Application Ref:	3/2026/0647			 Ribble Valley Borough Council www.ribblevalley.gov.uk
Date Inspected:	15/09/26	Site Notice:	15/09/26	
Officer:	LW			
DELEGATED ITEM FILE REPORT:				REFUSAL

Development Description:	Variation of condition 2 (plans) on permission 3/2026/0140 for proposed demolition of existing dwelling, and replacement with one new dwelling (self-build), outbuilding and garage.
Site Address/Location:	Rose Hill Farm, Whalley Old Road, Billington, BB7 9JF.

Proposed Site Plan - Ground Floor
Scale 1:200

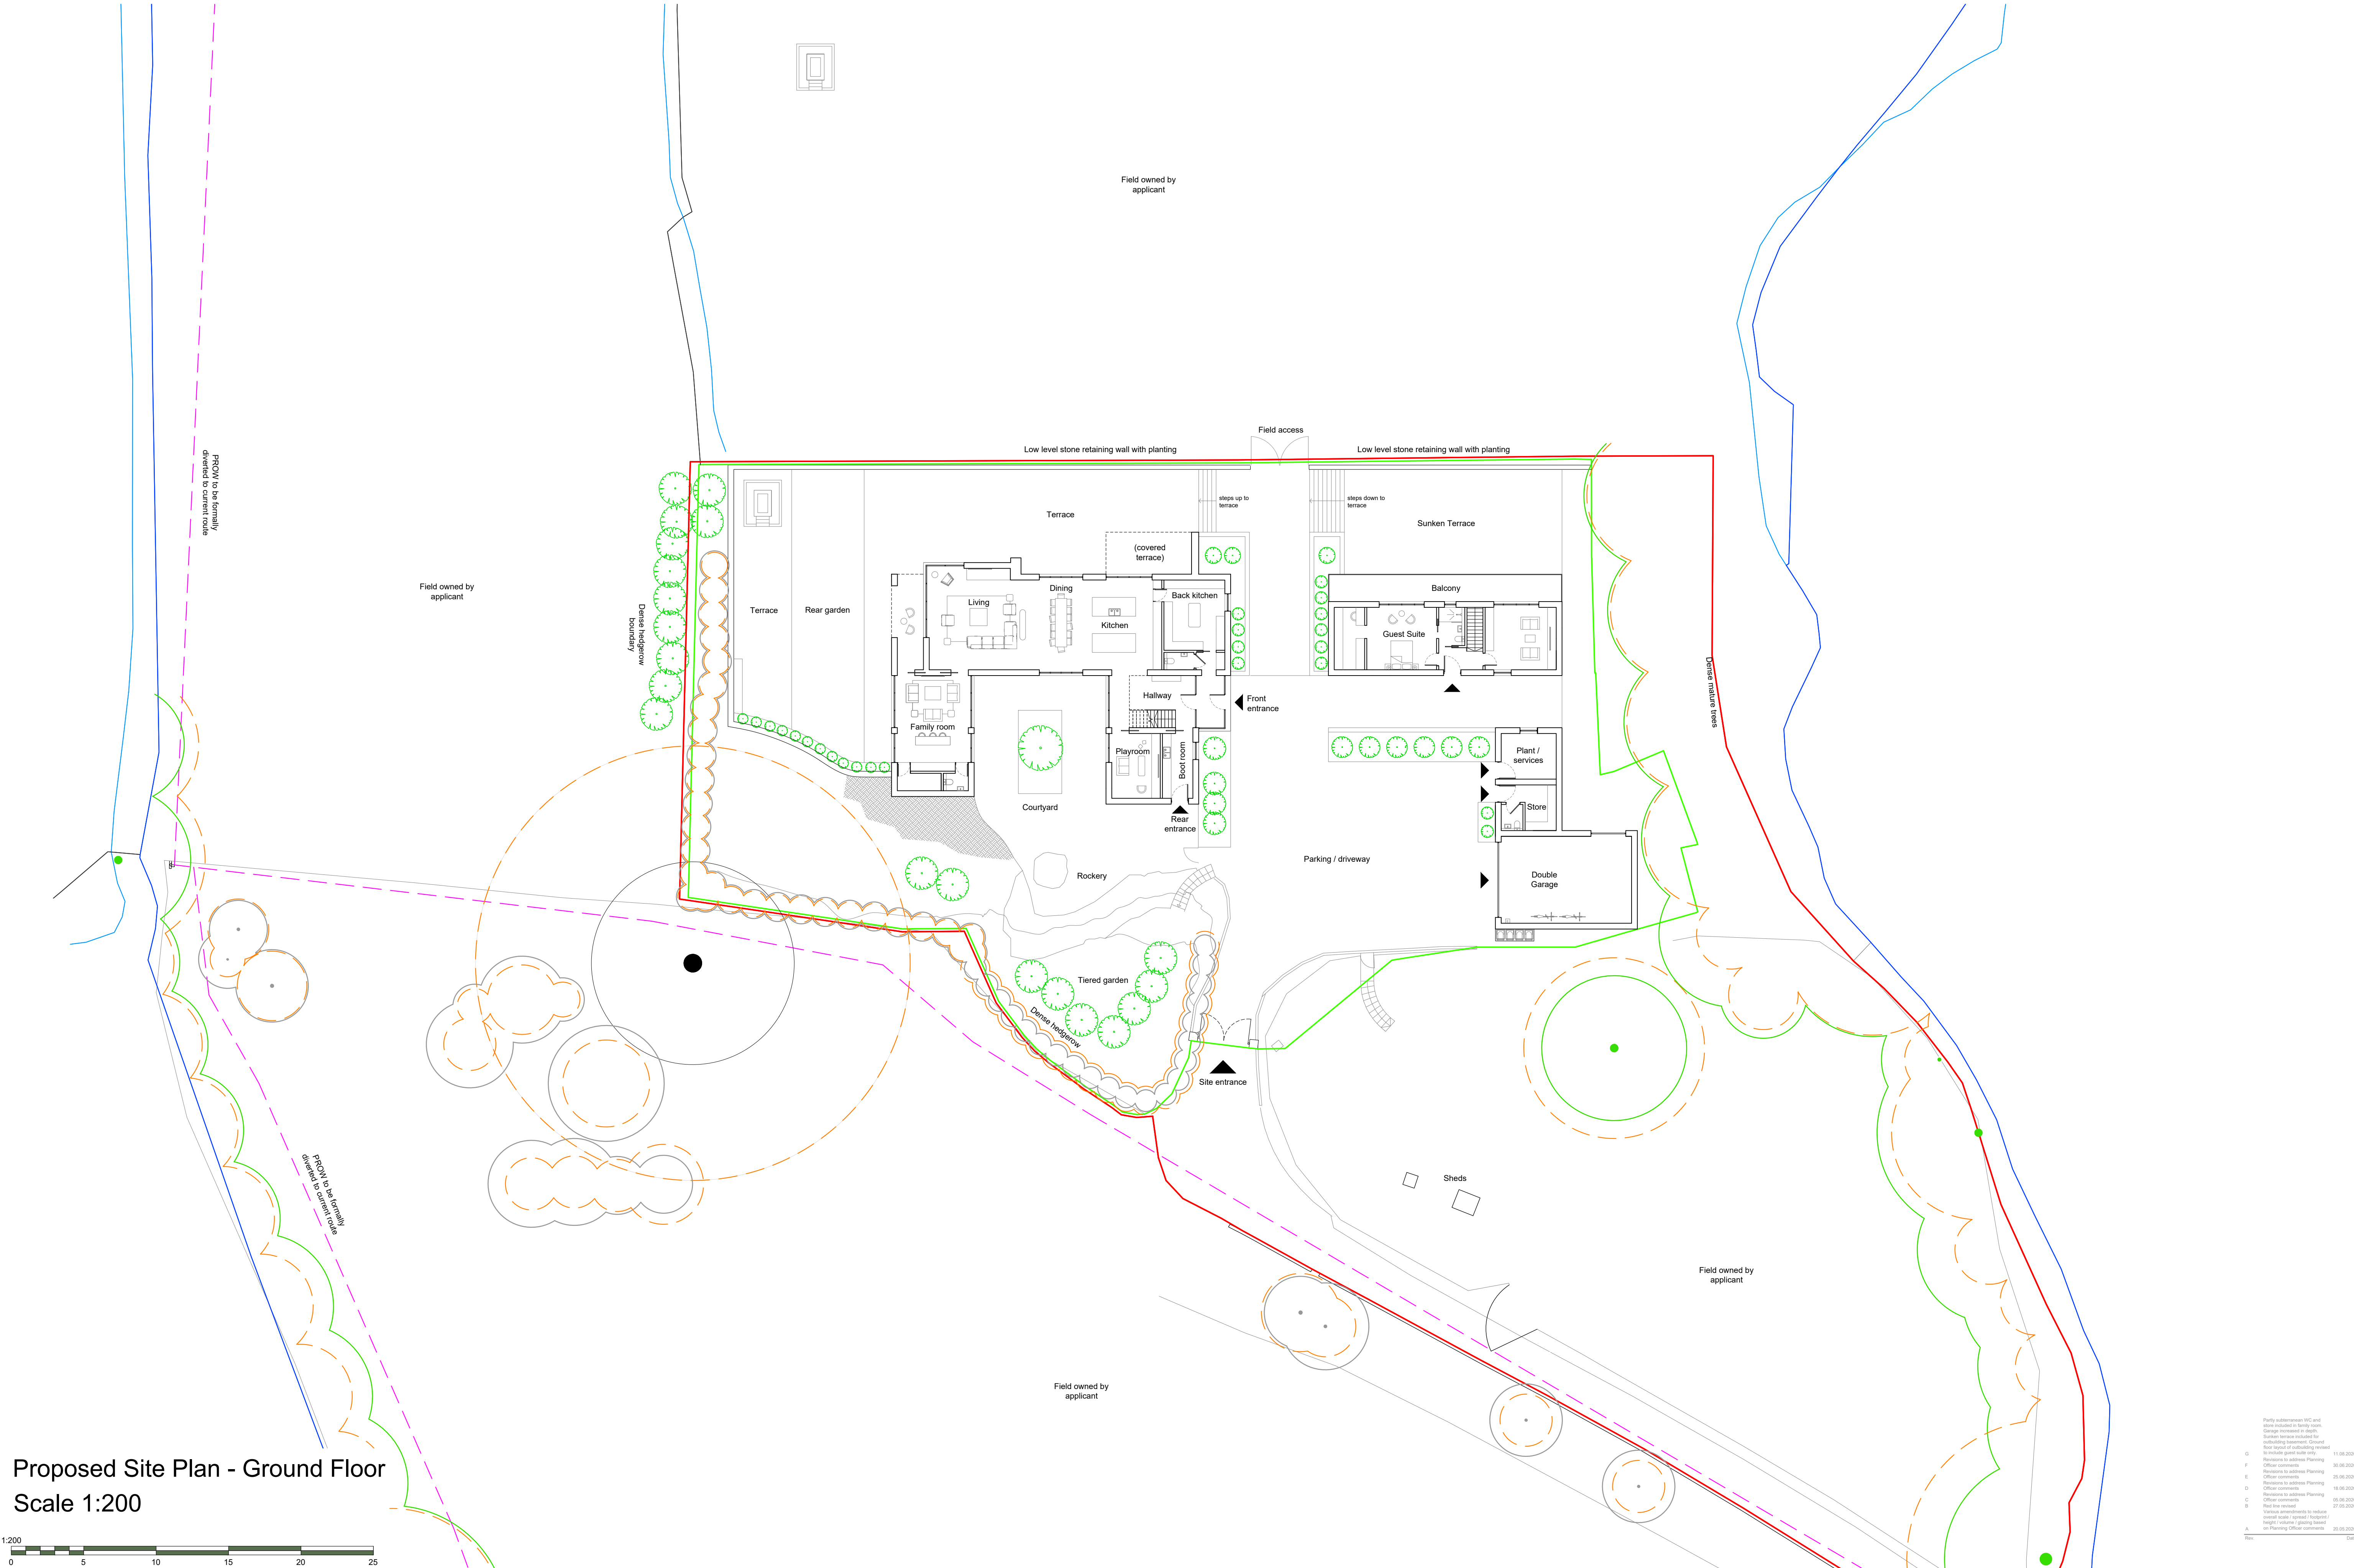
Whilst it is acknowledged that the additional accommodation proposed within the outbuilding would be positioned below ground level, the submitted plans indicate that the basement level would open directly onto a new sunken terrace. In practical terms, this would create a two-storey outbuilding with a maximum footprint of approximately 16.1m by 7m. Although sectional drawings have not been submitted, the proposal would clearly increase the scale, complexity and domestic presence of the outbuilding beyond that previously approved.

Similarly, the proposed extension to the detached garage would increase the scale and visual presence of what is already a substantial additional ancillary building. The garage approved under application 3/2026/0140 comprised a relatively modest double garage with an attached store and plant room. The current proposal seeks to increase the depth of the building by approximately 3m, resulting in a structure with a maximum footprint of approximately 9.8m by 13.9m. This increase would further add to the cumulative extent of built form on the site and would reduce the subordinate appearance expected of a domestic garage building.

The proposed amendments have the potential to impact upon trees within or adjacent to the site by virtue of bringing built development and engineering works closer to the root protection areas of retained trees than the previously approved scheme. However, an updated Arboricultural Impact Assessment and Tree Protection Plan has not been submitted in support of this application.

Proposed Ground Floor Plan
Scale 1:100

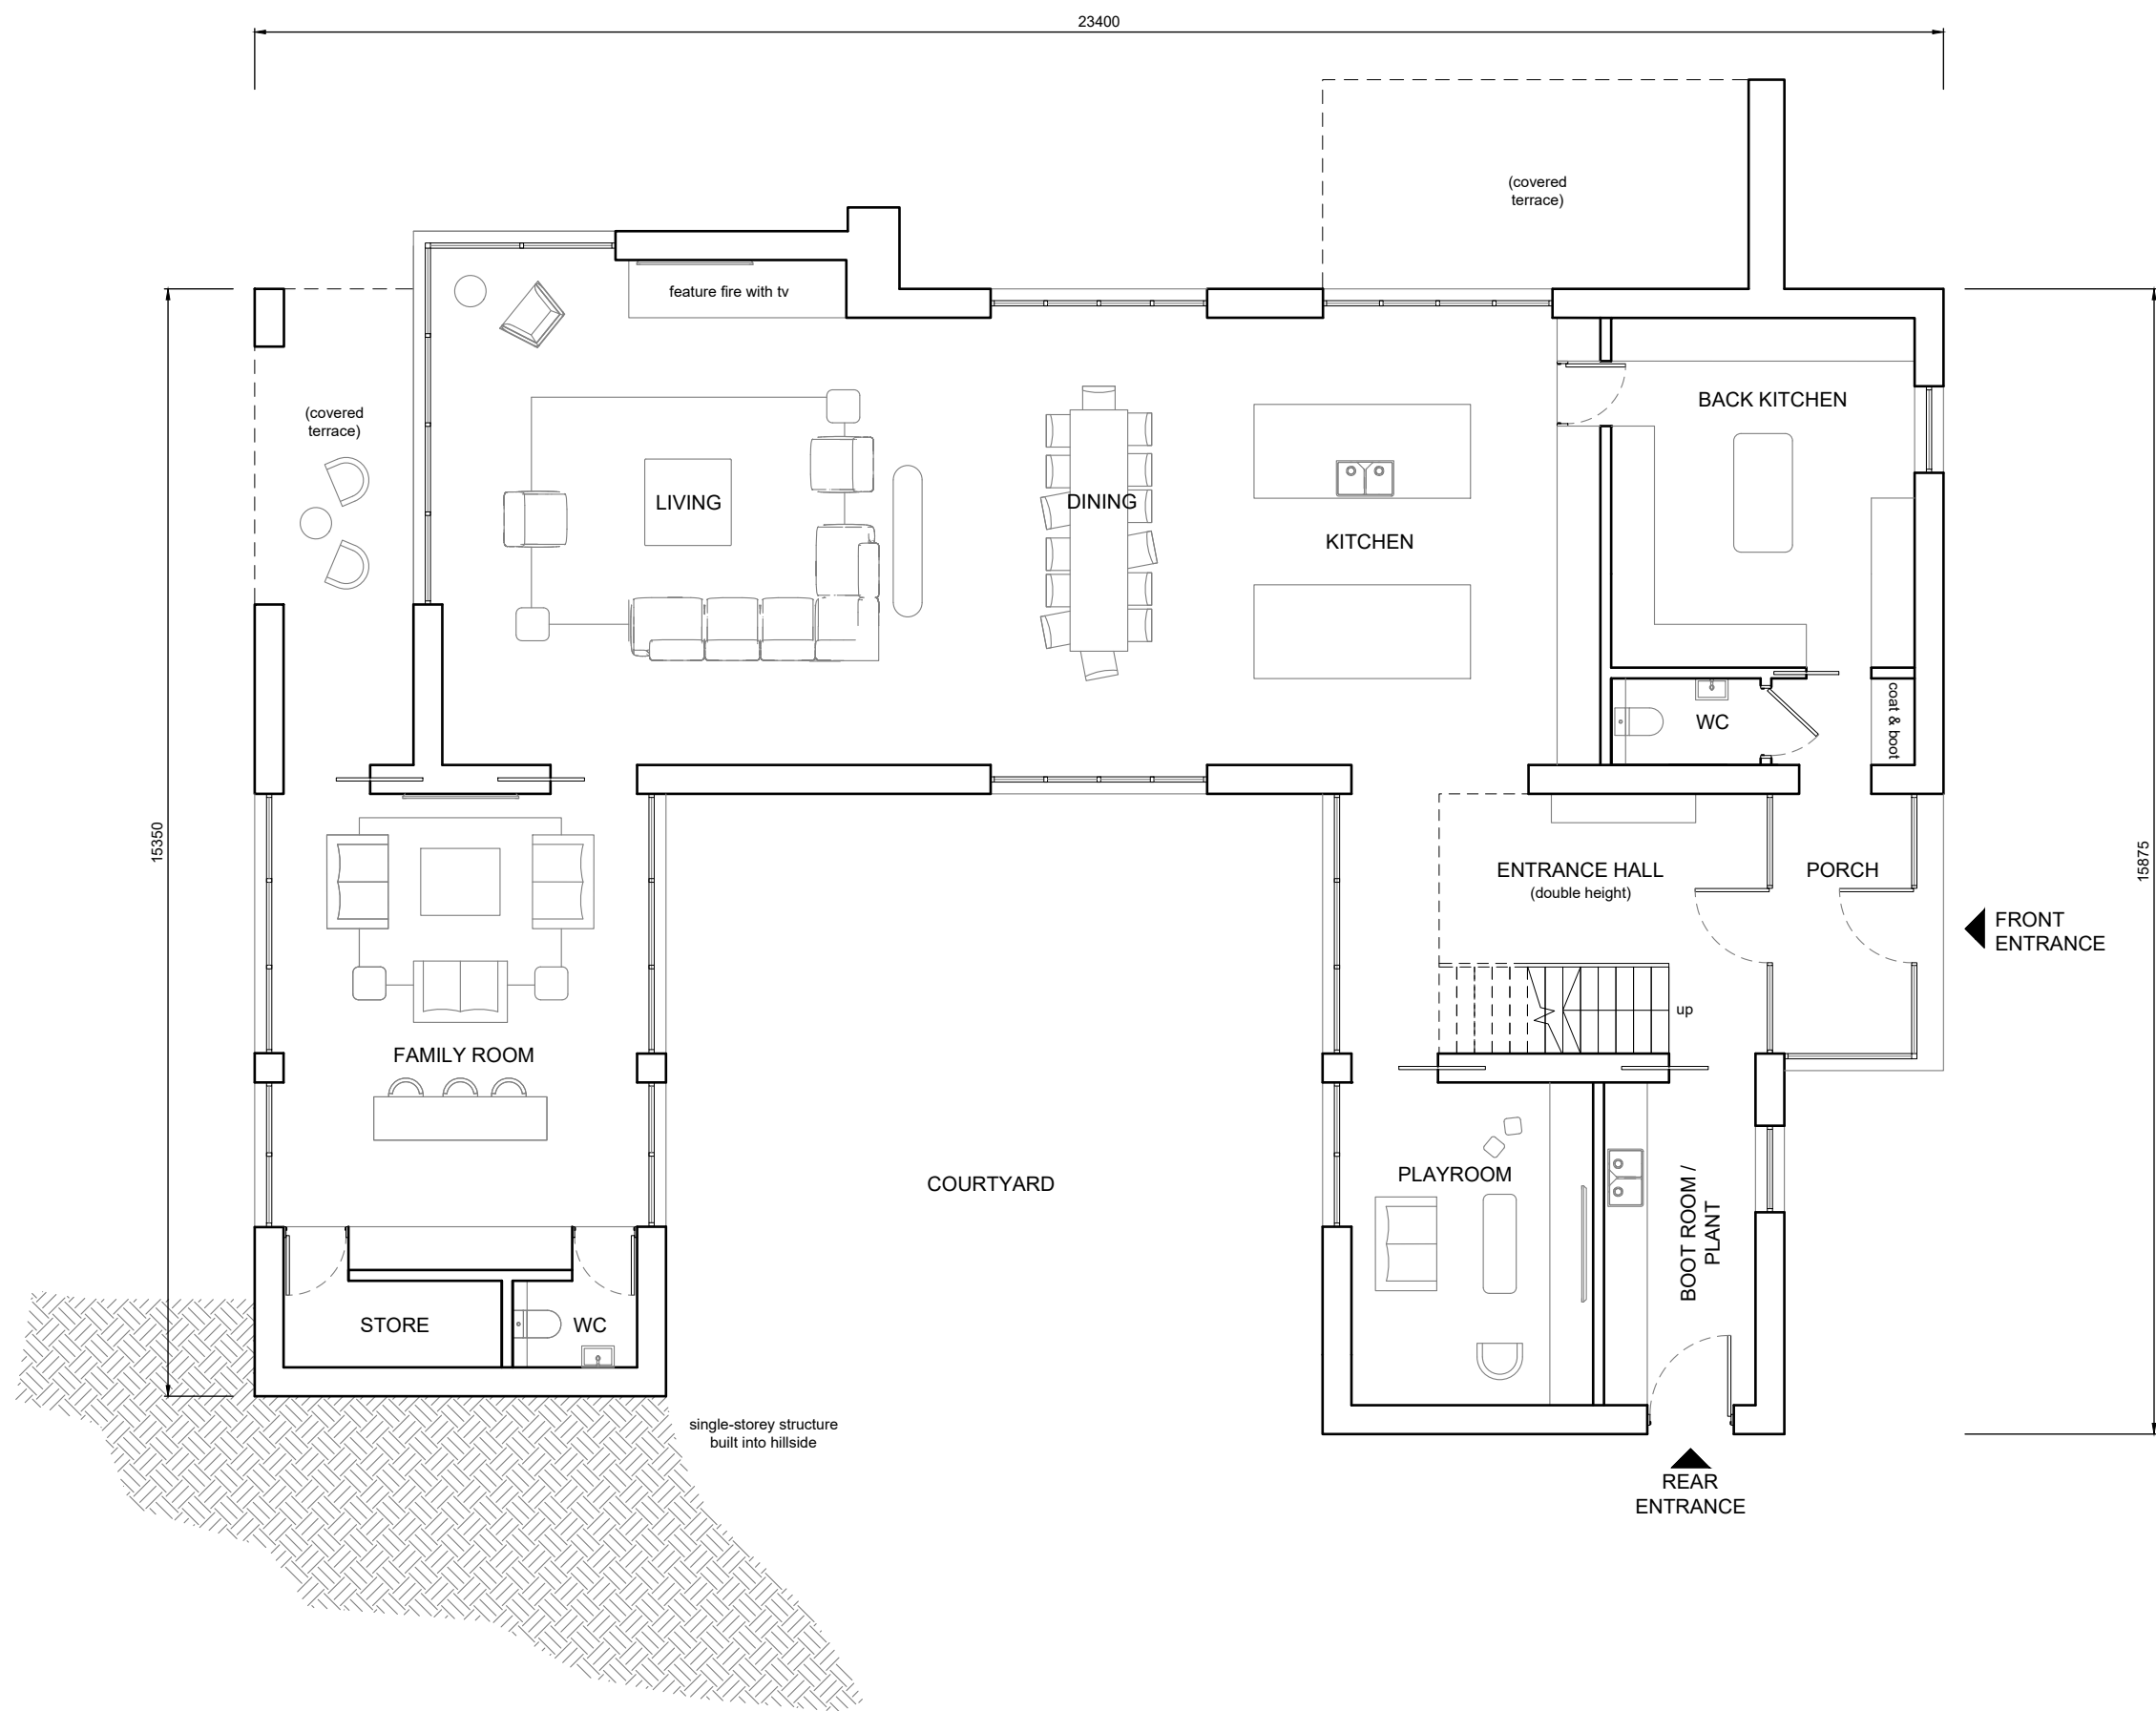
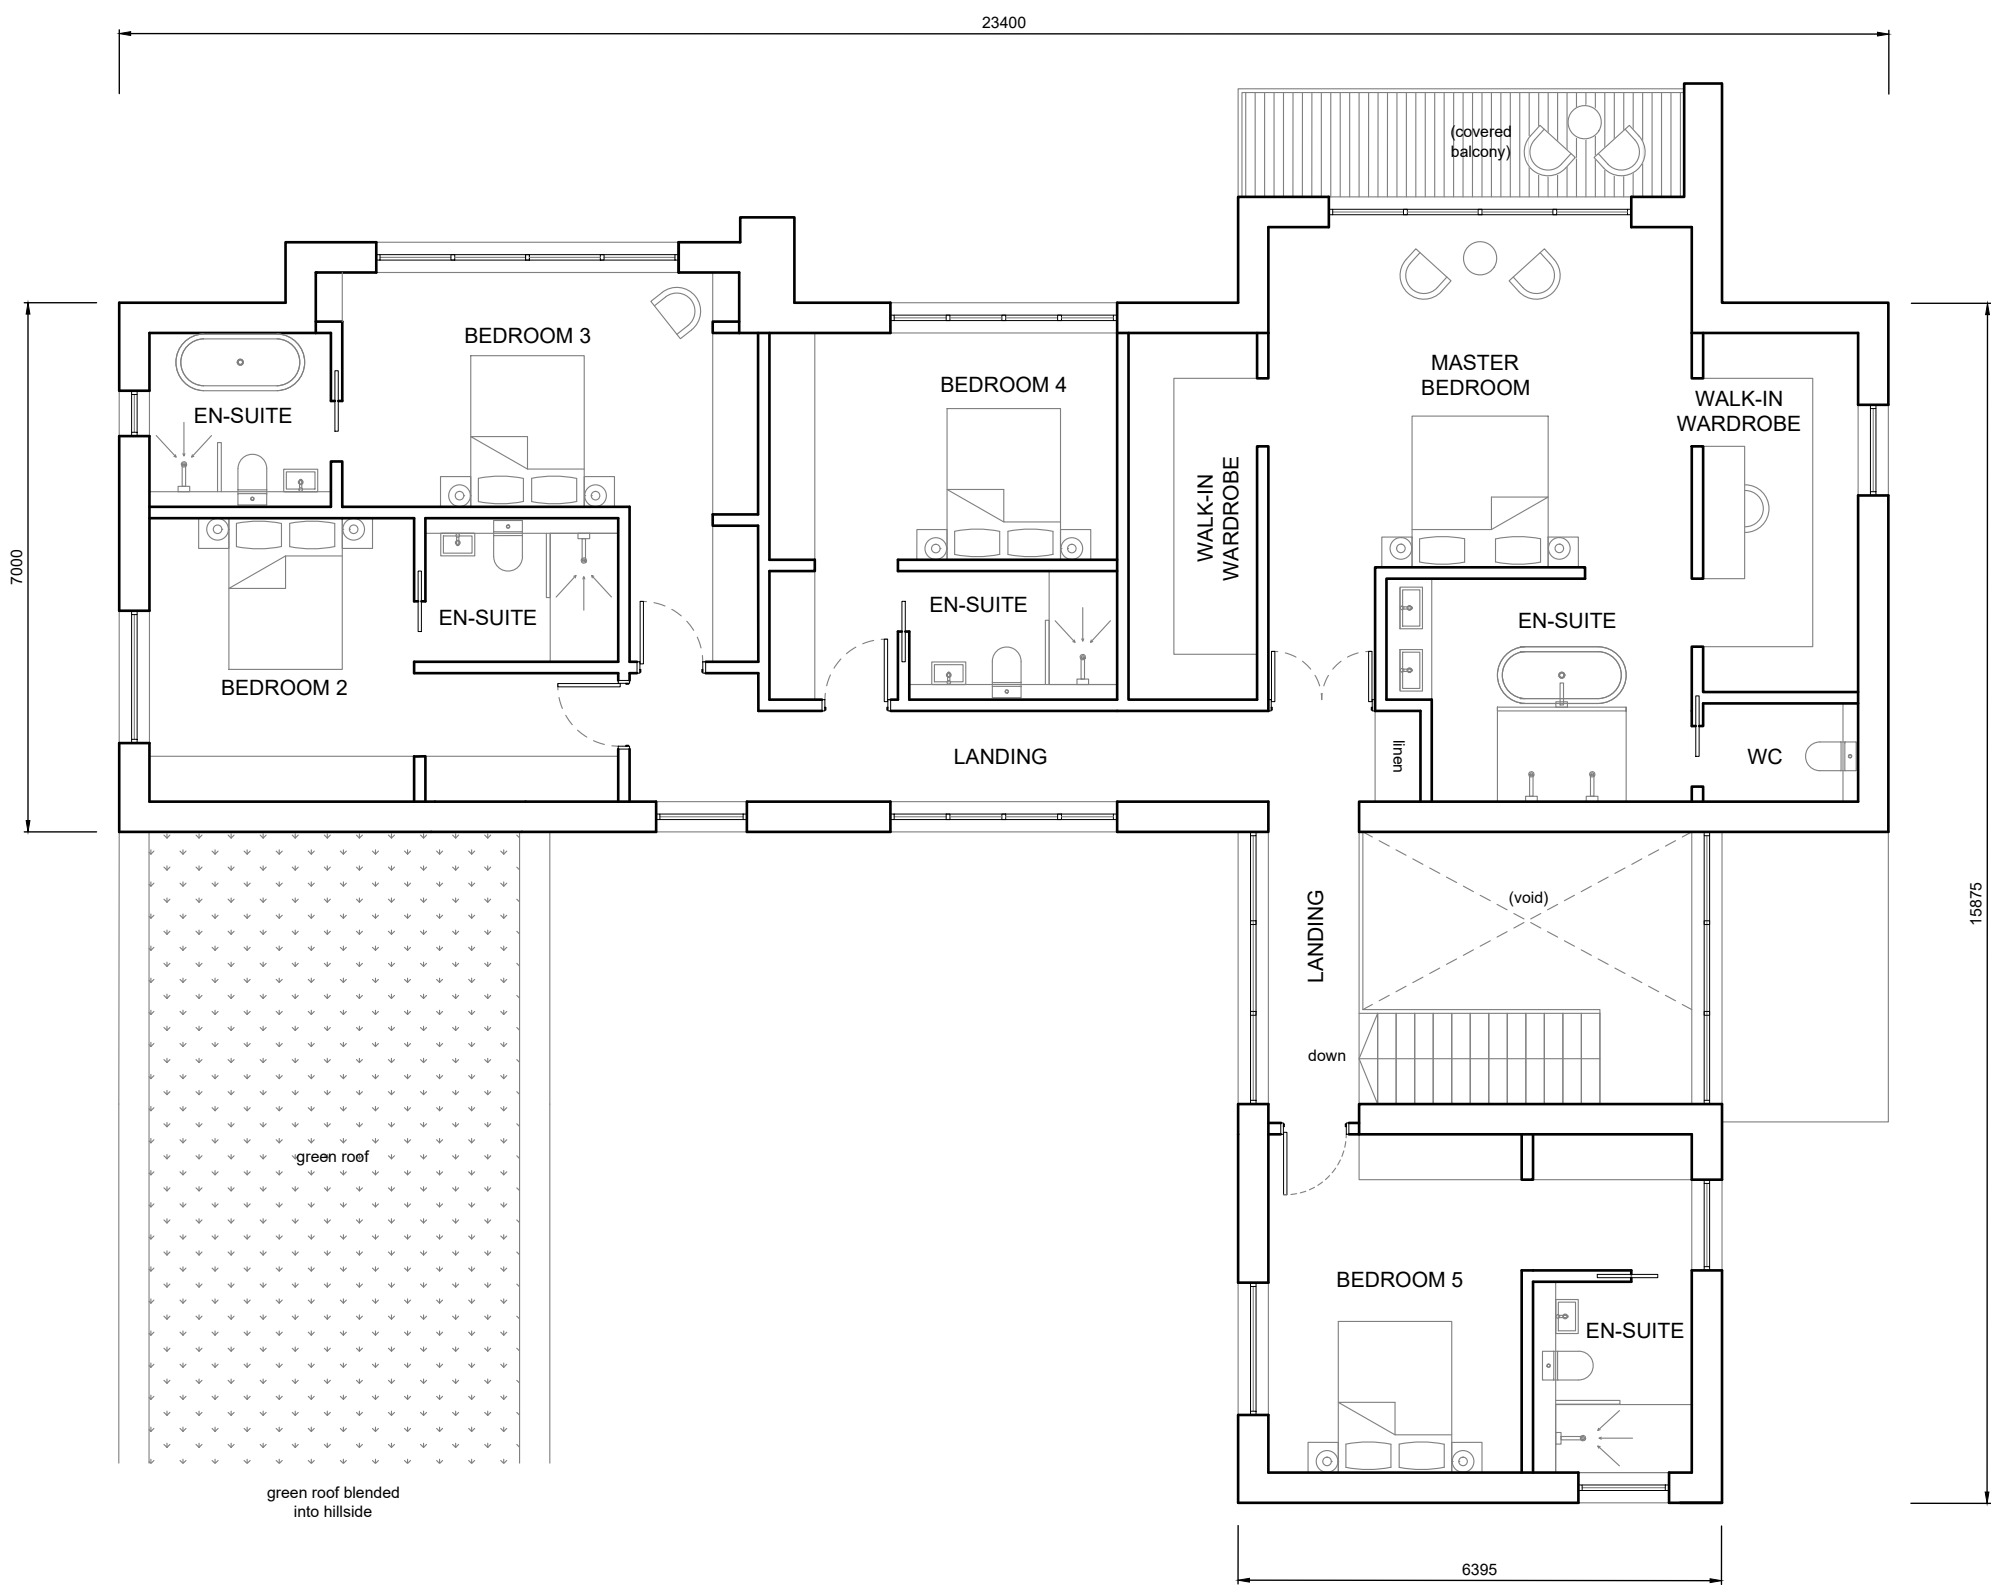
The amendments proposed under the current application would increase the overall quantum of development approved under application 3/2026/0140 through the provision of a part-subterranean WC to the main dwellinghouse, a basement level beneath the approved outbuilding opening onto a new sunken terrace, together with a new ground-floor balcony, and an increase in the depth of the garage.

It is acknowledged that the additional accommodation within the dwellinghouse and outbuilding would be set into the ground and would therefore have a more limited visual impact than equivalent above-ground development. However, these elements nevertheless represent an increase in the scale and extent of built development at the site. Furthermore, the excavation works required to facilitate the part subterranean WC, basement accommodation and sunken terrace would introduce additional engineered features which were not present within the approved scheme.
